From: Sarah Burrow <Sarah.Burrow@arun.gov.uk>
Sent: 18 November 2019 17:19
To: Amber Willard <Amber.Willard@arun.gov.uk>
Cc: Planning.Responses <Planning.Responses@arun.gov.uk>
Subject: RE: BN/87/19/HH Melcroft

Engineers Comments Regarding Surface Water Drainage

From: Clint Clements
Sent: 18 November 2019 08:36
To: Amber Willard <Amber.Willard@arun.gov.uk>
Subject: BN/87/19/HH Melcroft

Poposed Rainwater
Drainage A2

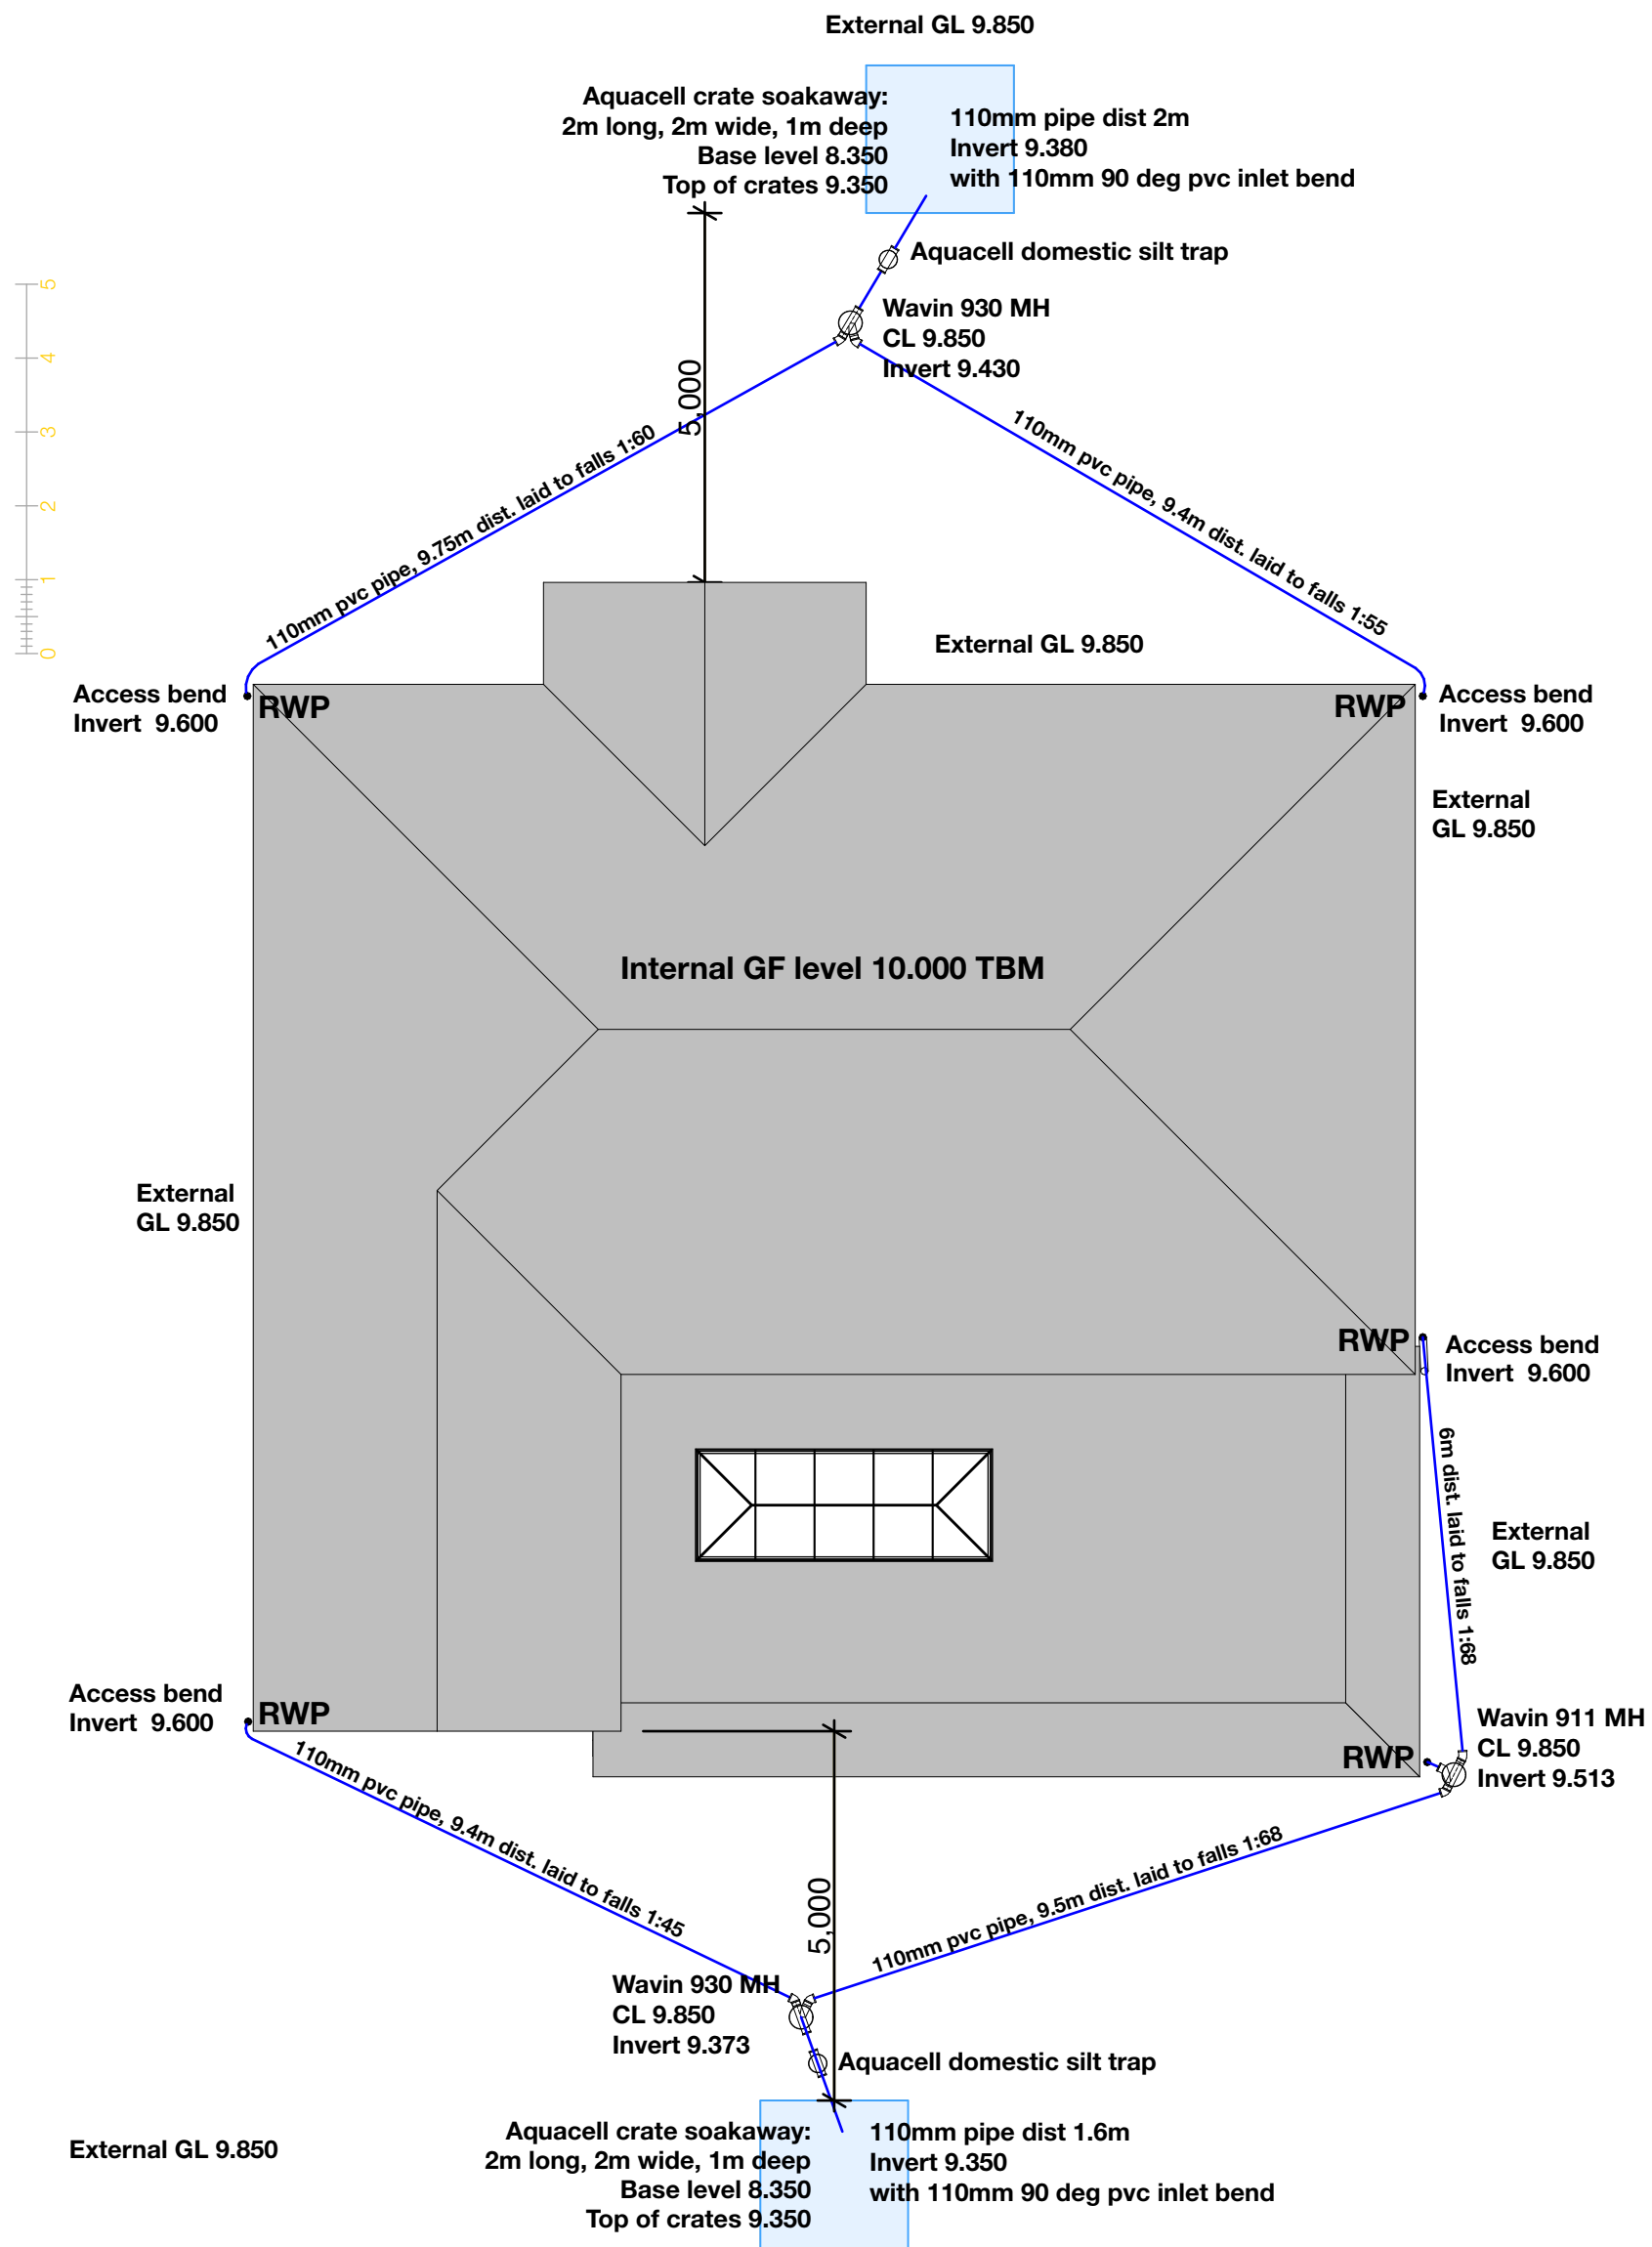
Please disregard the initial request for standard surface water drainage condition PCENG2 to be applied to this application. The surface water drainage system for the development should be in accordance with "Proposed Rainwater Drainage A2" Drawing and "Drainage-Melcroft V2" Calculations.
